**WELWYN HATFIELD BOROUGH COUNCIL
DIRECTORATE OF STRATEGY AND DEVELOPMENT**

DELEGATED APPLICATION

Application No: 6/2016/0923/HOUSE
Location: 25 Northaw Road East, Cuffley, Potters Bar, EN6 4LU
Proposal: Roof alteration from hip to gable, erection of rear extension to include 2no front dormer windows and installation of front porch
Officer: Mrs J Pagdin
Recommendation: Granted

FRONT ELEVATION

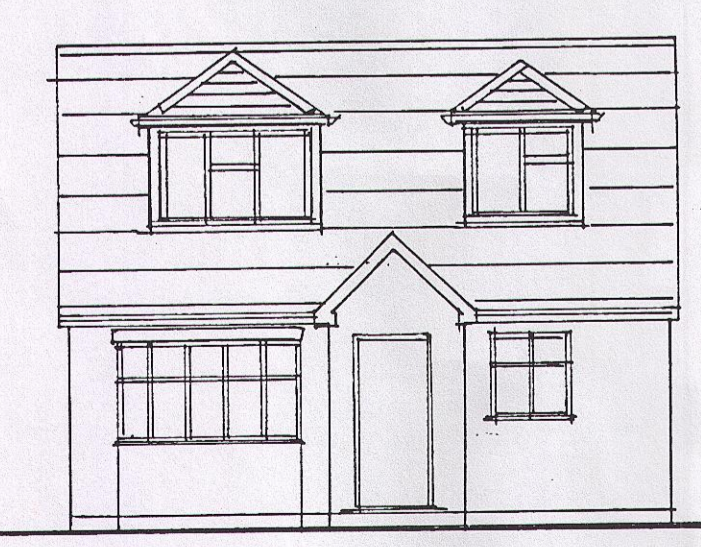
Comment (if applicable): n/a			
Would the development reflect the character of the area? And the dwelling?			
Yes No			
Comment (if applicable):			
<p>The main changes to the building would be at roof level. The height of the roof would be increased by 0.5m and the shape facing the front would change from hipped to flat-end gables on each side. While this would make the roof wider at higher level it would not result in the building looking cramped on its site as the existing spaces between the building and boundaries would be retained.</p> <p>The ridge would not be significantly higher than the existing roof and would pitch to the front. The two front dormers would be small (1.5m and 2.3m wide) and have pitched roofs over. They would be set in from the side of the roof by 1m or more and they would be set down below the height of the main ridge by 0.1m and 0.3m. The new roof and dormers would be finished in tiles to match the texture and colour of the existing roof and, when viewed from the road, would not be unduly</p>

Several bungalows in the row have had roof alterations and the proposals are not out of keeping with the scale of alterations at other houses in the vicinity. However, in creating flat-end gables instead of box dormers to the sides, the roof form would be simpler than some of the nearby examples and be more appropriate to the style of the house.

SOUTH ELEVATION

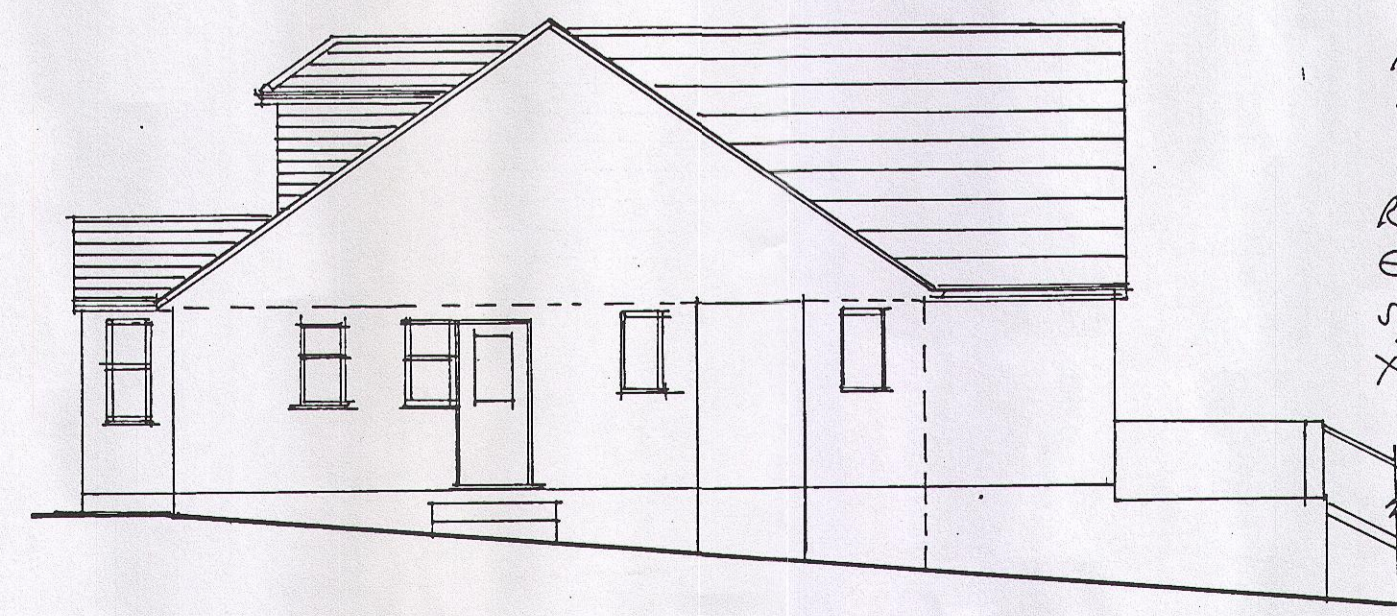
With regard to privacy, there would be no new windows installed in the south facing side elevation. A side door would replace part of one window. This would not give rise to a significant increase in overlooking or loss of privacy to No 27 over and above the existing situation.

NORTH ELEVATION

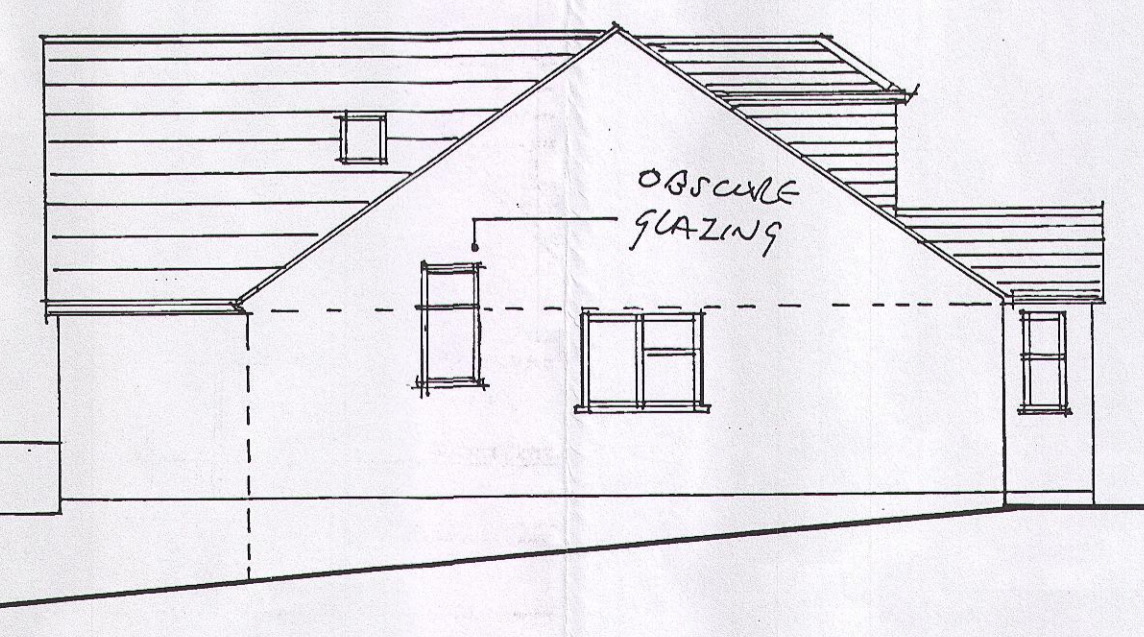
One new window to the stairway would be installed in the north facing boundary but this would be obscure glazed to prevent overlooking of the space to the side of the house at No 23.

3. The proposed stair window in the north facing elevation of the building shall be glazed with obscured glass and shall be fixed so as to be incapable of being opened below a height of 1.8 metres above floor level, and shall be retained in that form thereafter.
